Two storey extension to front elevation, new verandah & relocation of front door, raise rear pitch roof, extend garage with pitch roof & remodel existing dormers with pitch roofs.

4 Apple Grove Aldwick

Thank you for your internet representation made on 8th November 2017 which has been recorded as '**an objection**' with the comments as follows:

Title
Plans as Proposed

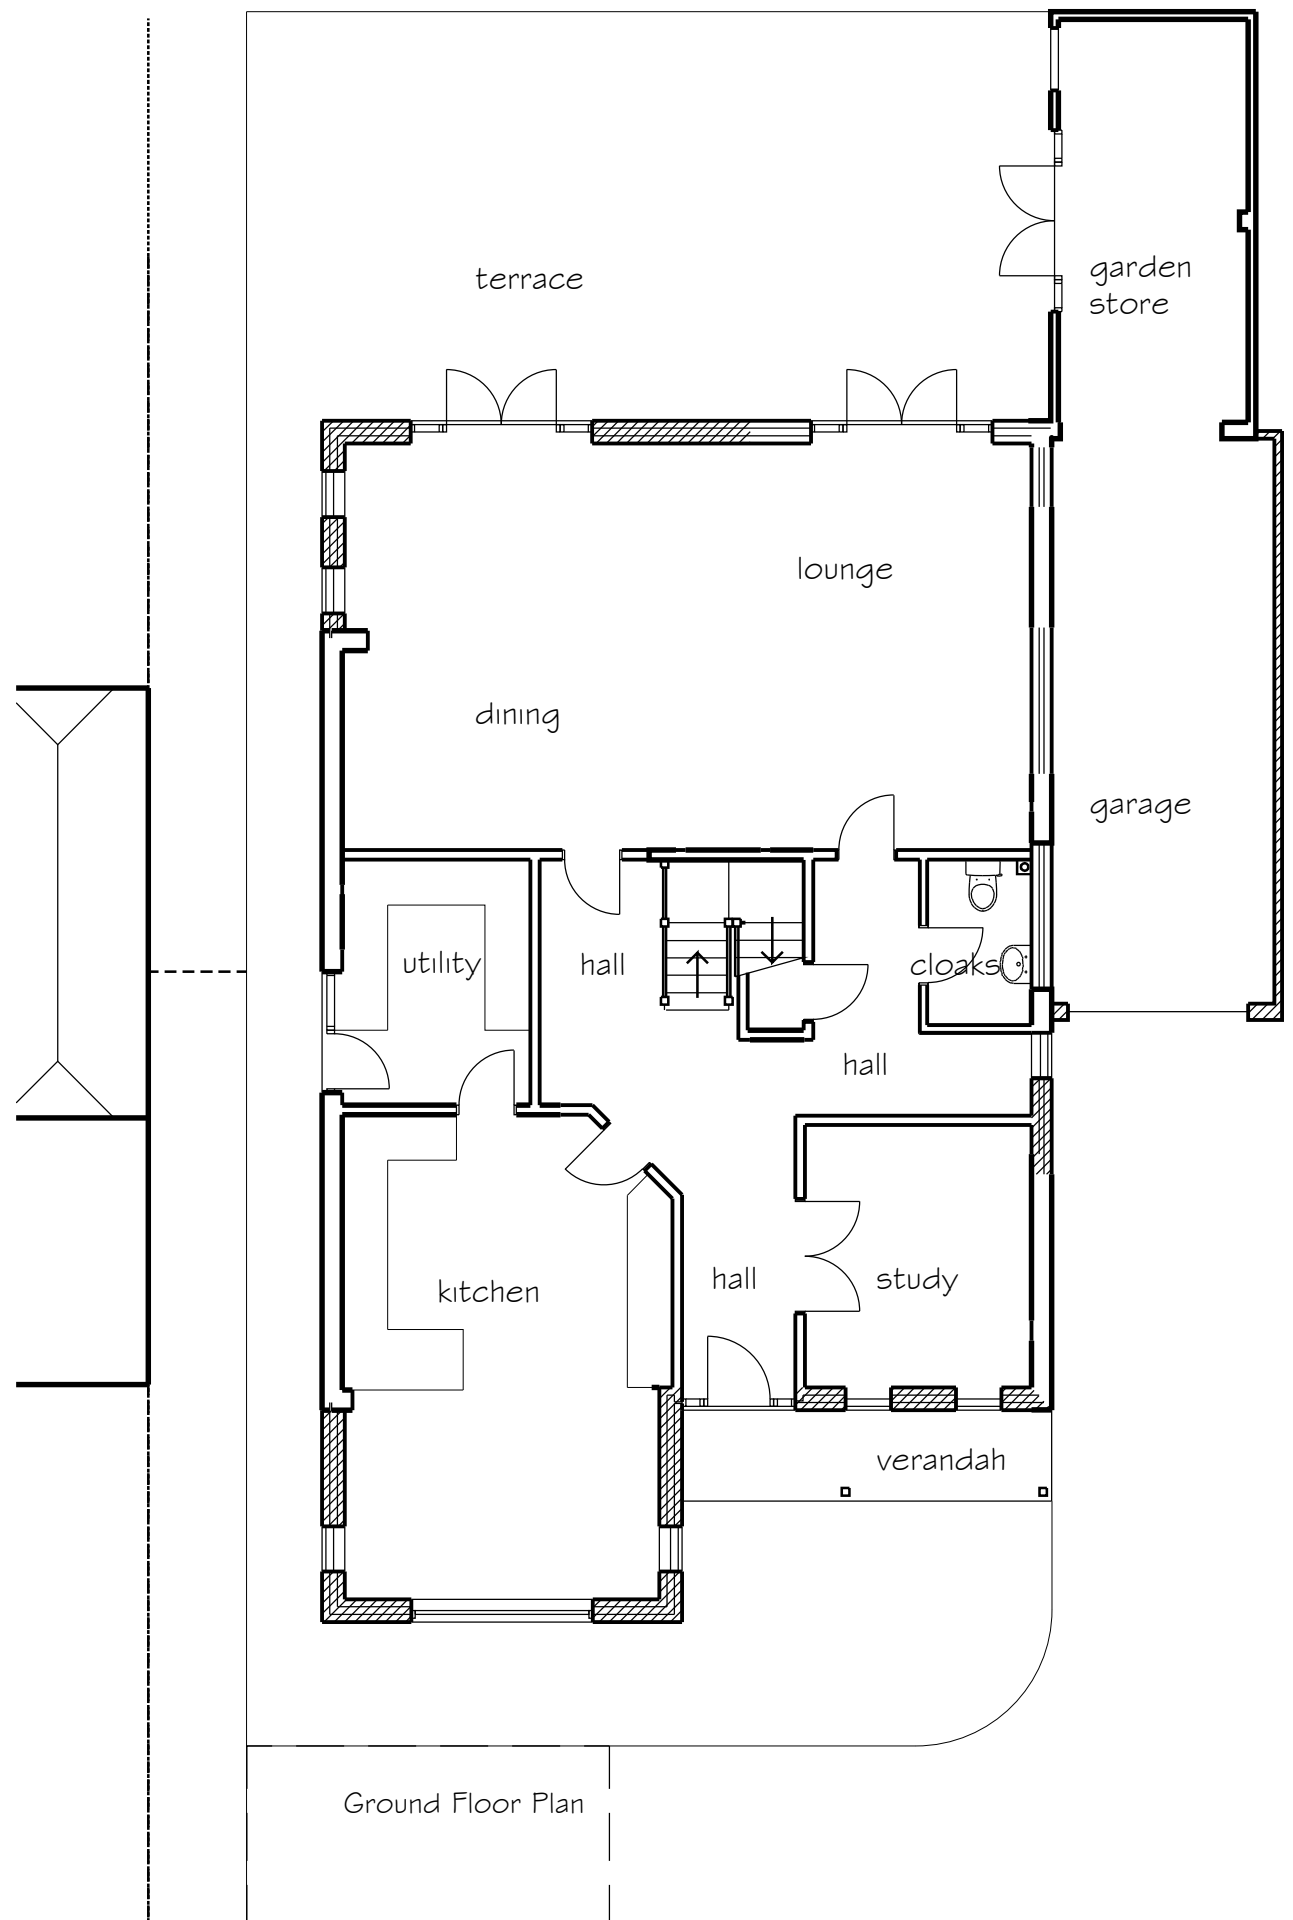
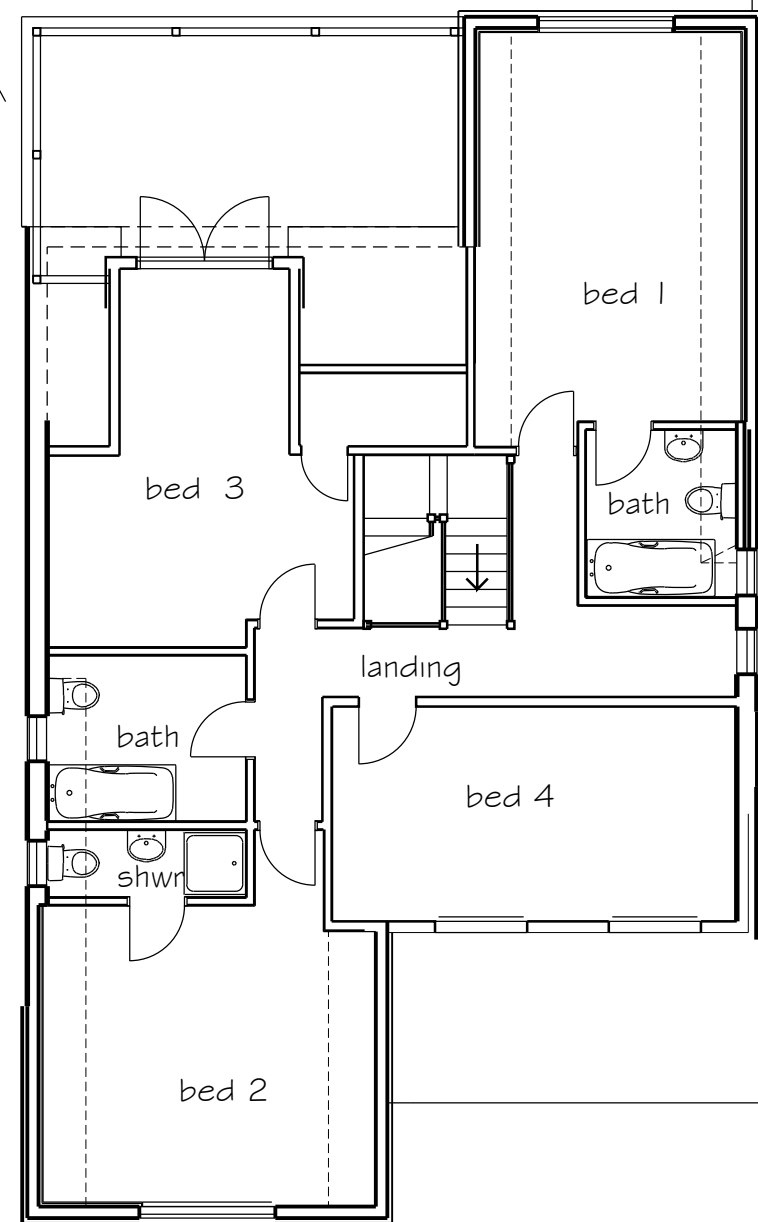
We are concerned that the proposed rear two storey extension will obstruct our right to light, not just to the side of the house but also to our rear (single storey) extension. This room was very carefully planned and designed to provide a bright and pleasant living and kitchen area in a north facing aspect. In addition to the doors and windows to the rear and a window on the right hand side, it is lit from above in four separate areas with four domed roof windows, each of which measures approximately 130x86 cm.

The size of the long window on the first floor to the side of the property facing ours is also a concern in terms of overlooking living areas in our property.
